Traffic Impact Study

Crossroads-Meadowbrook & Reagan Ranch Colorado Springs, Colorado

PCD File No. CR201 & SP207

Add PCD File No. P208 and SP2011
Unresolved.

# CROSSROADS AT MEADOWBROOK-MIXED USE PRELIMINARY PLAN

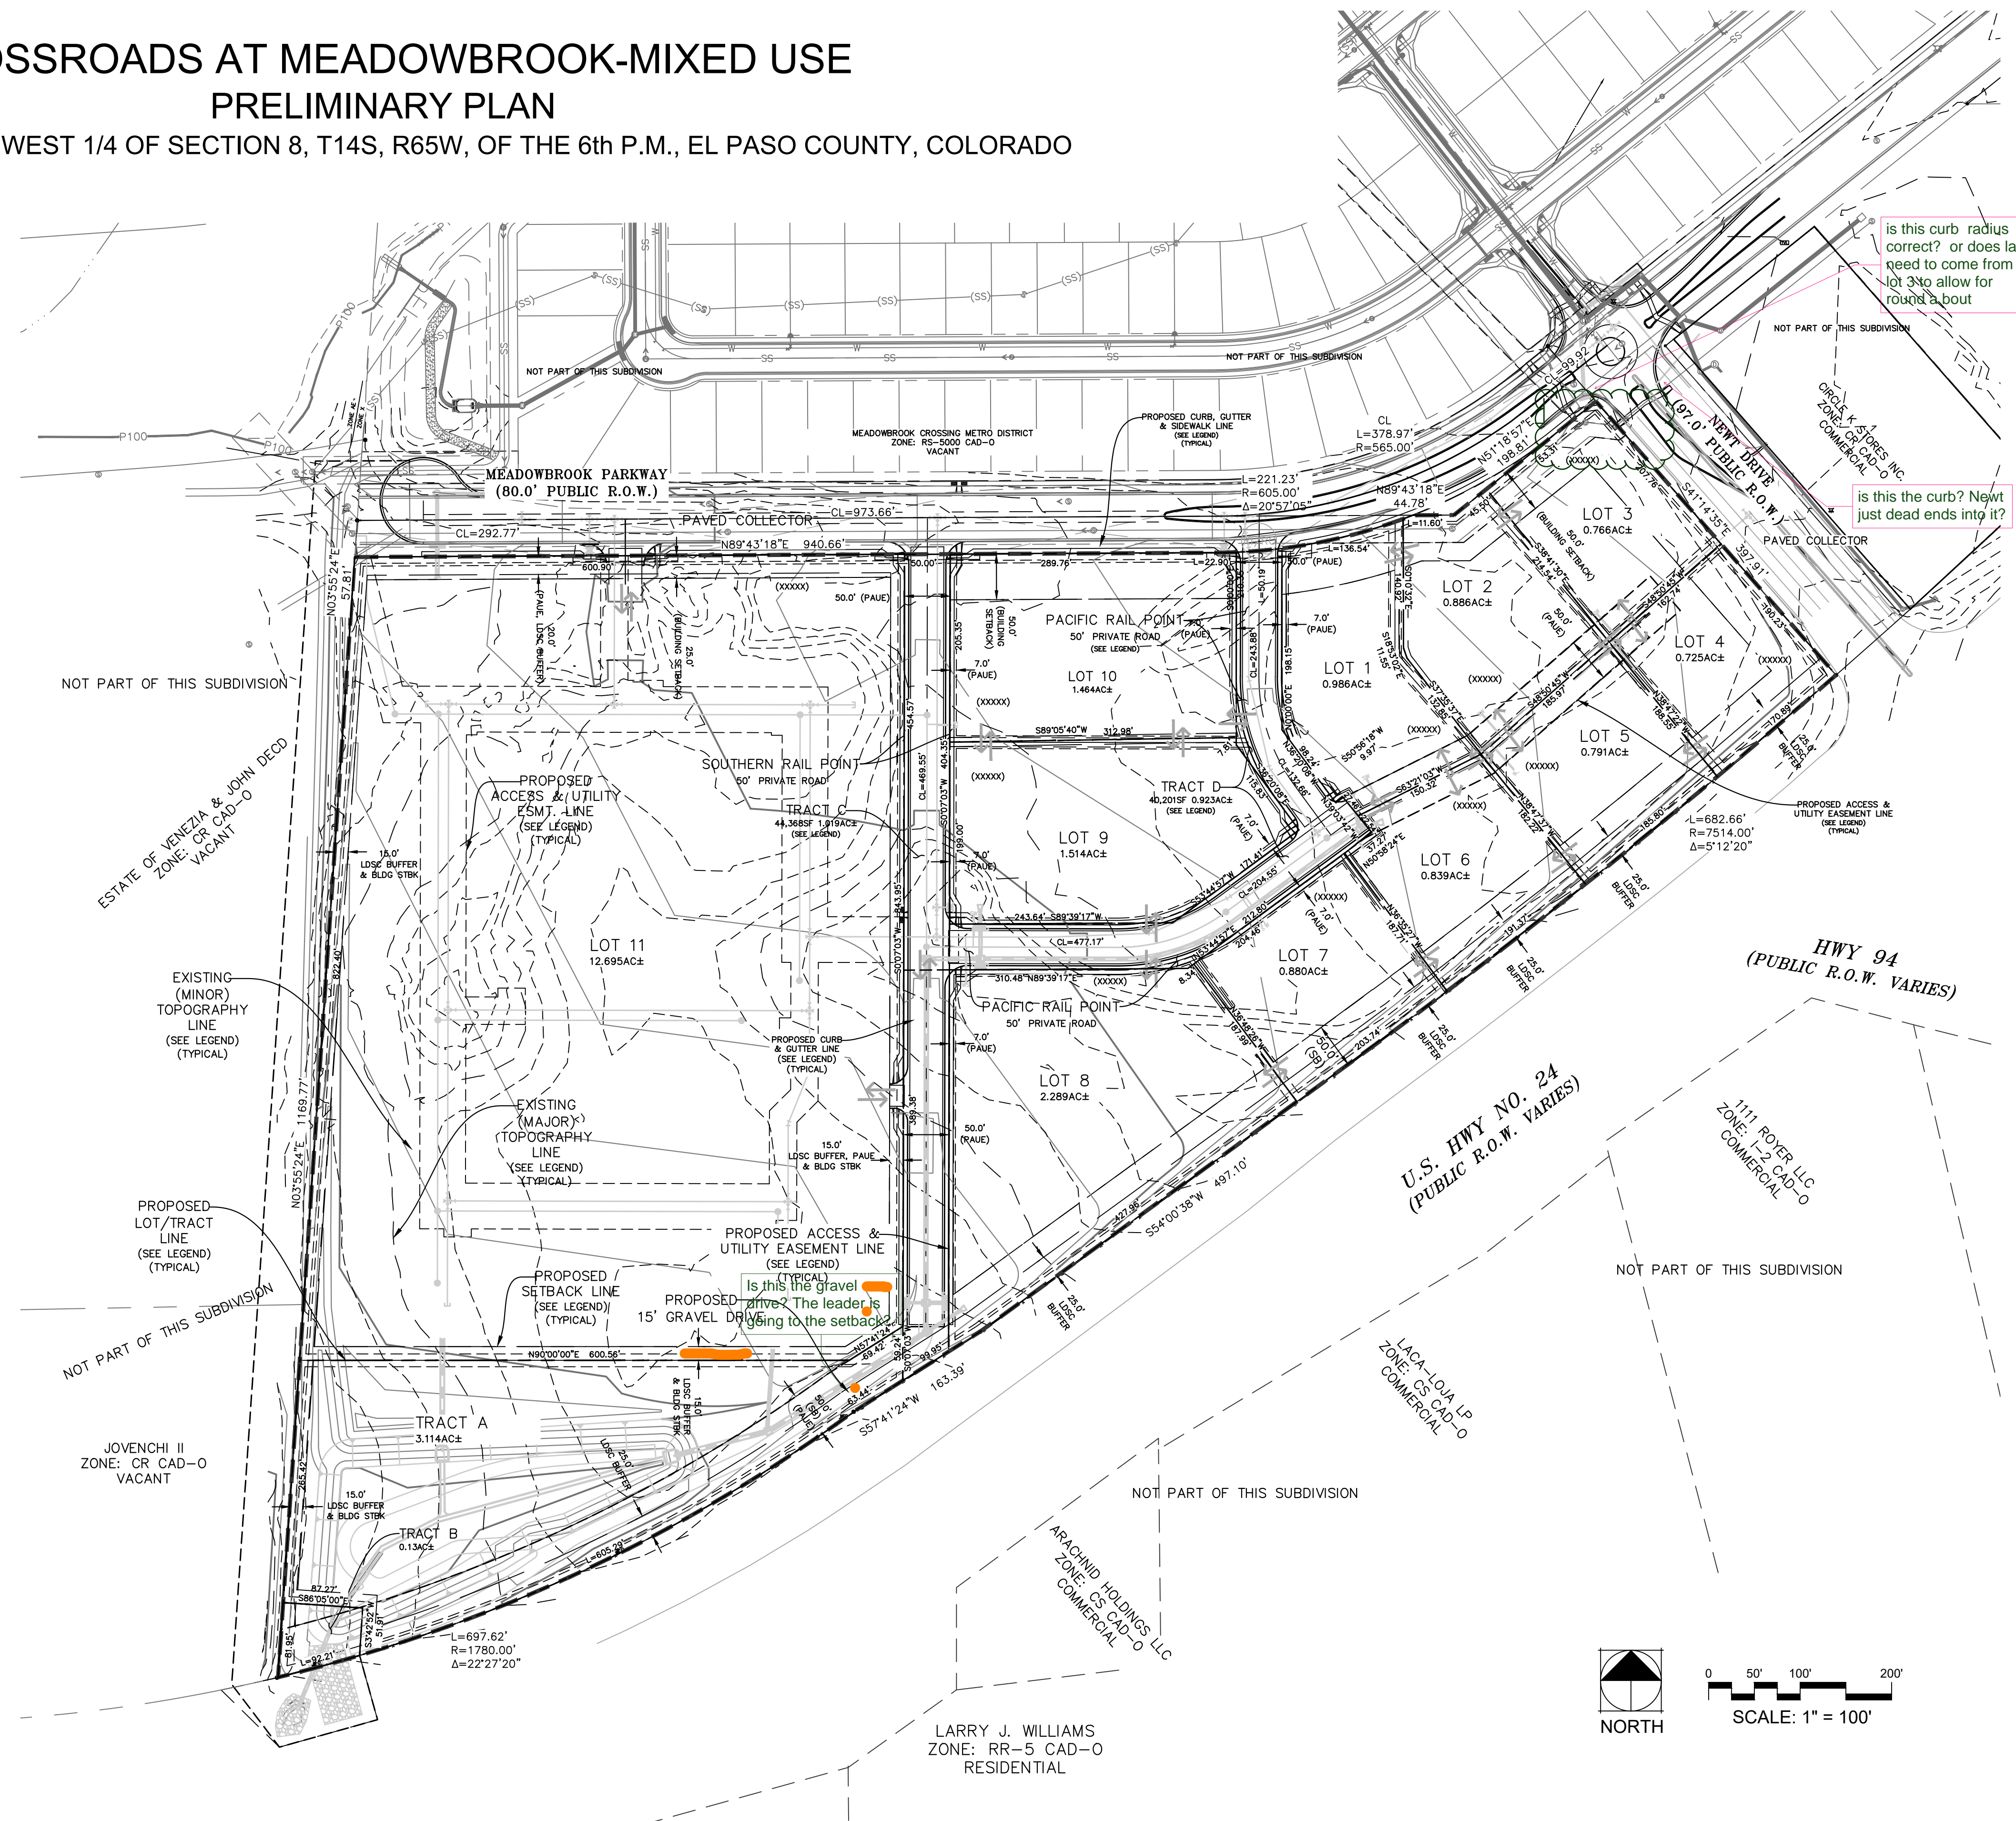
Update either the preliminary plan or the TIS analysis for consistency. The preliminary plan is showing full movement at the northeastern access.

# CROSSROADS AT MEADOWBROOK MIXED USE PRELIMINARY PLAN

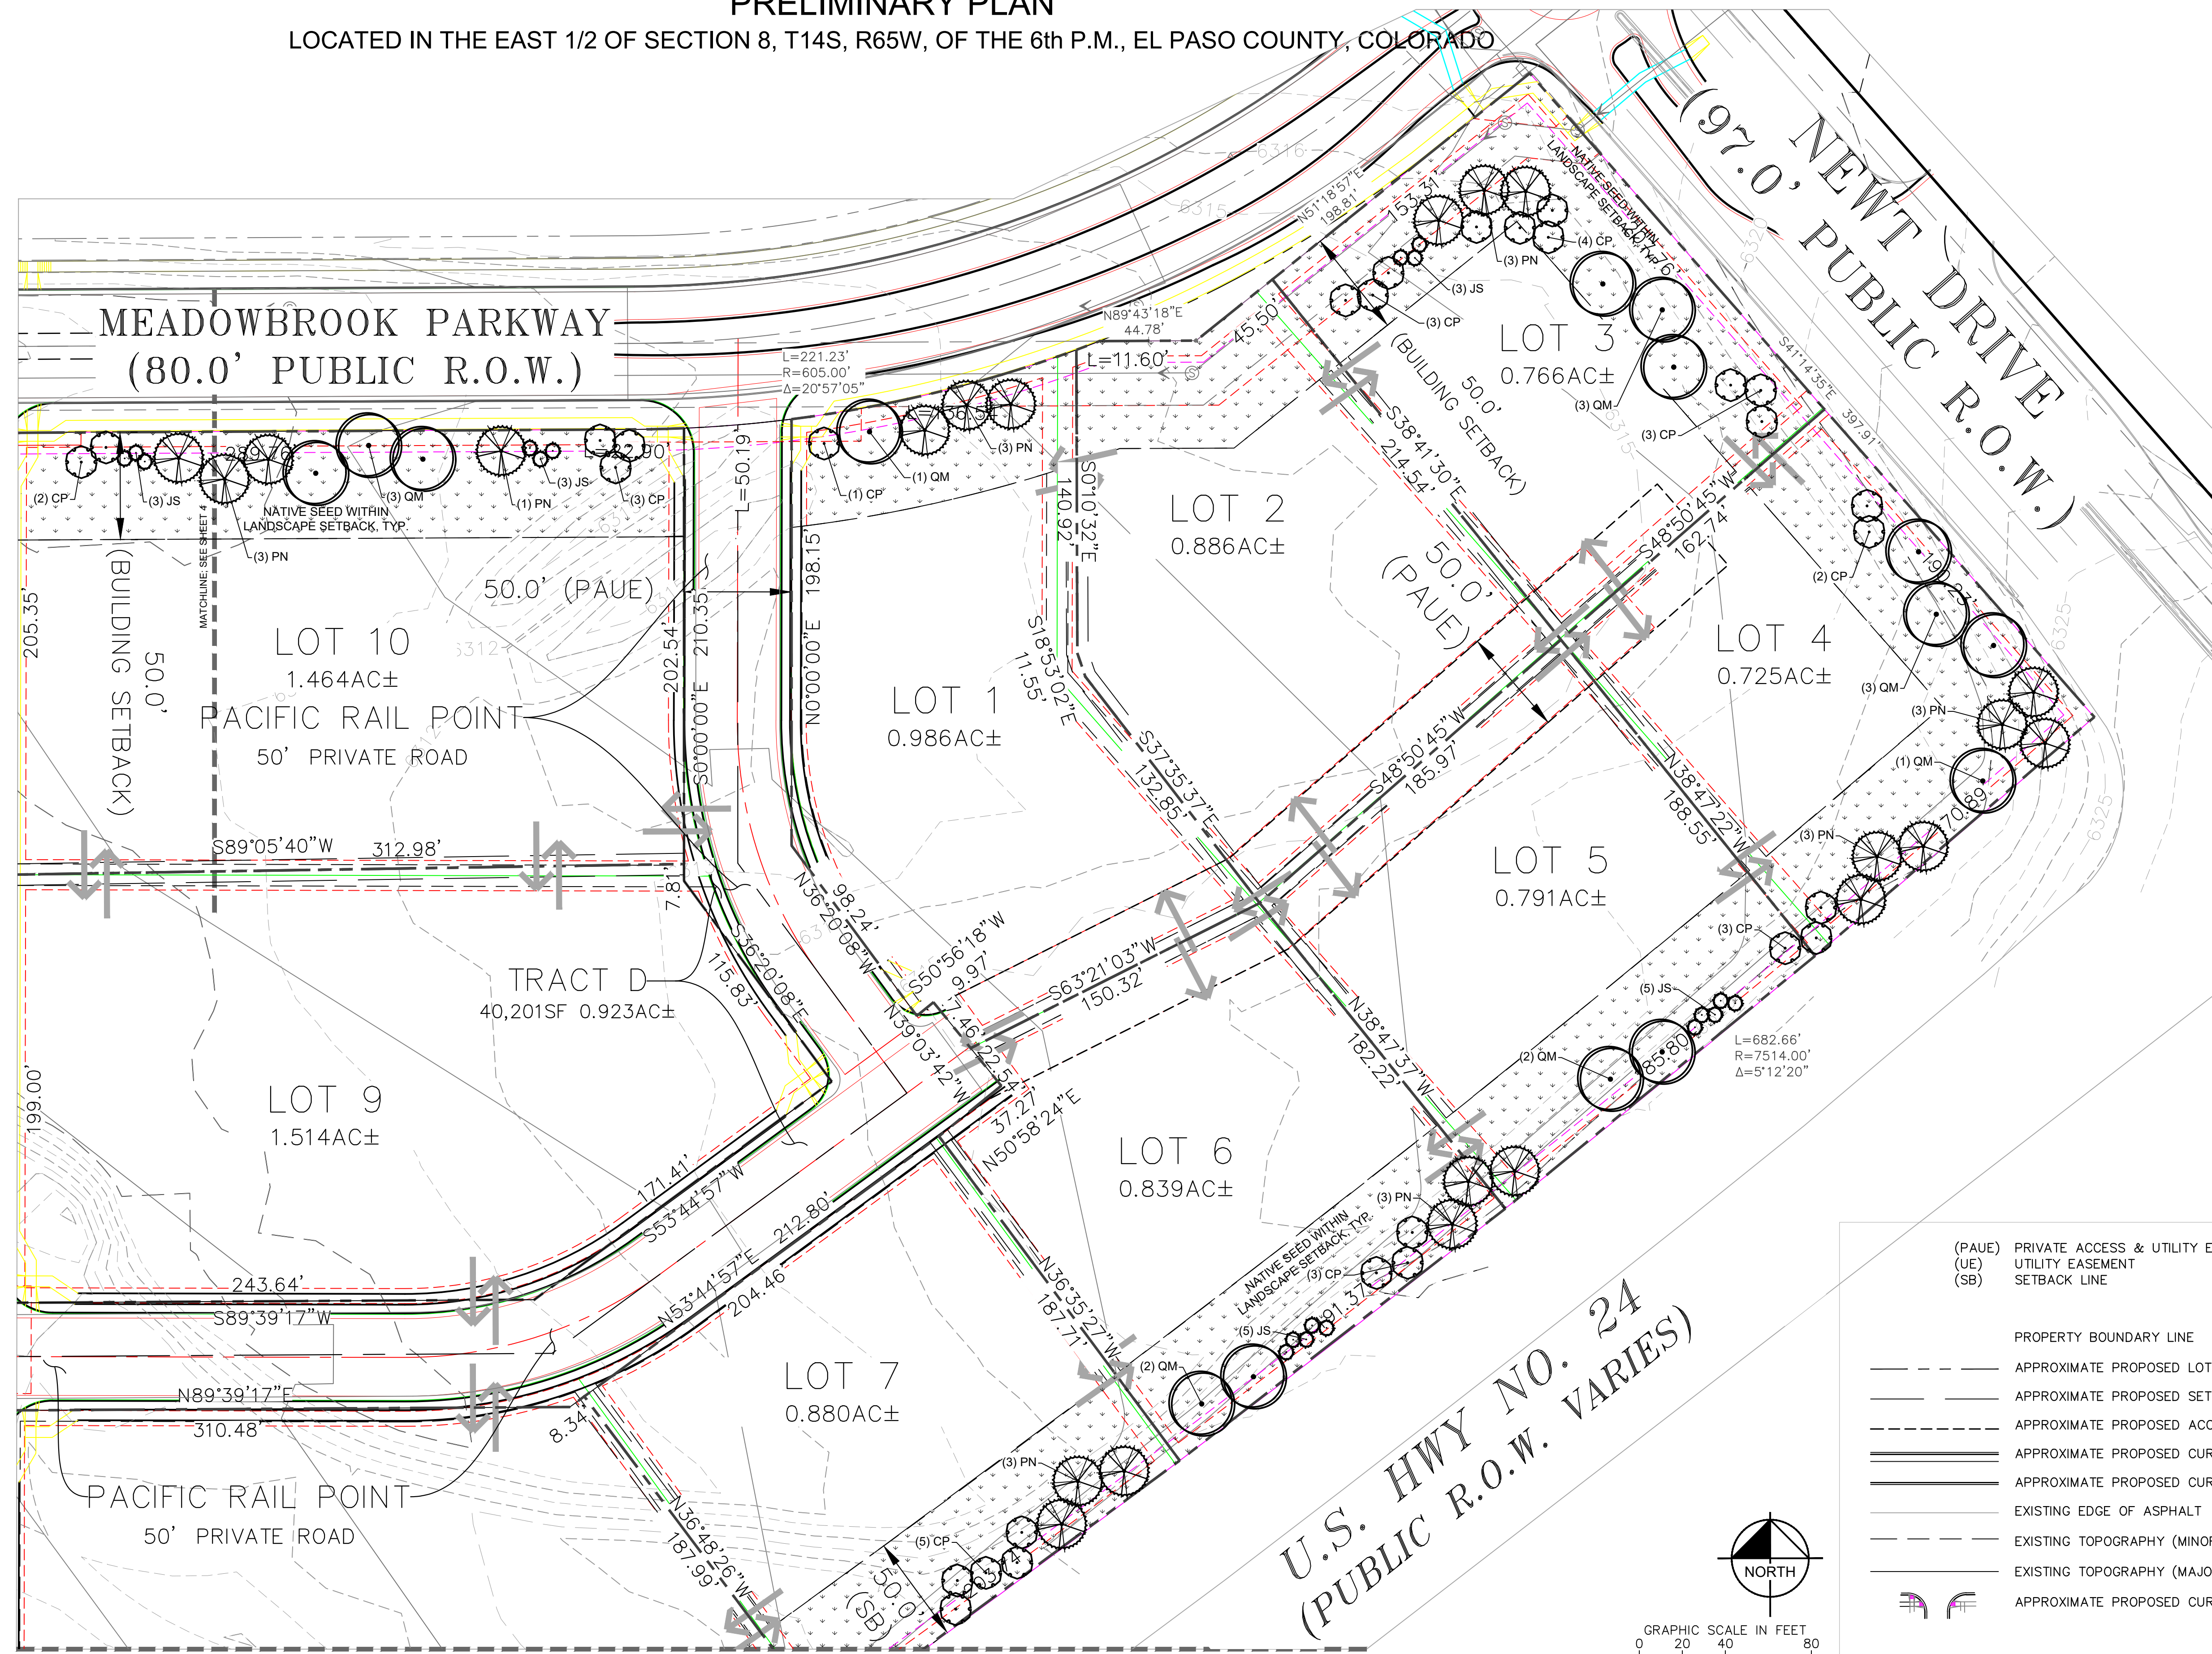
1. Provide recommendations for the internal private road classification/cross section in Crossroads Mixed Use. The trip generation estimate is 11,554 ADT while the preliminary plan showed an urban local road cross section (design ADT of 3,000) for the internal private road. **Unresolved. It seems the private road should be designed to a non-residential collector cross-section.**
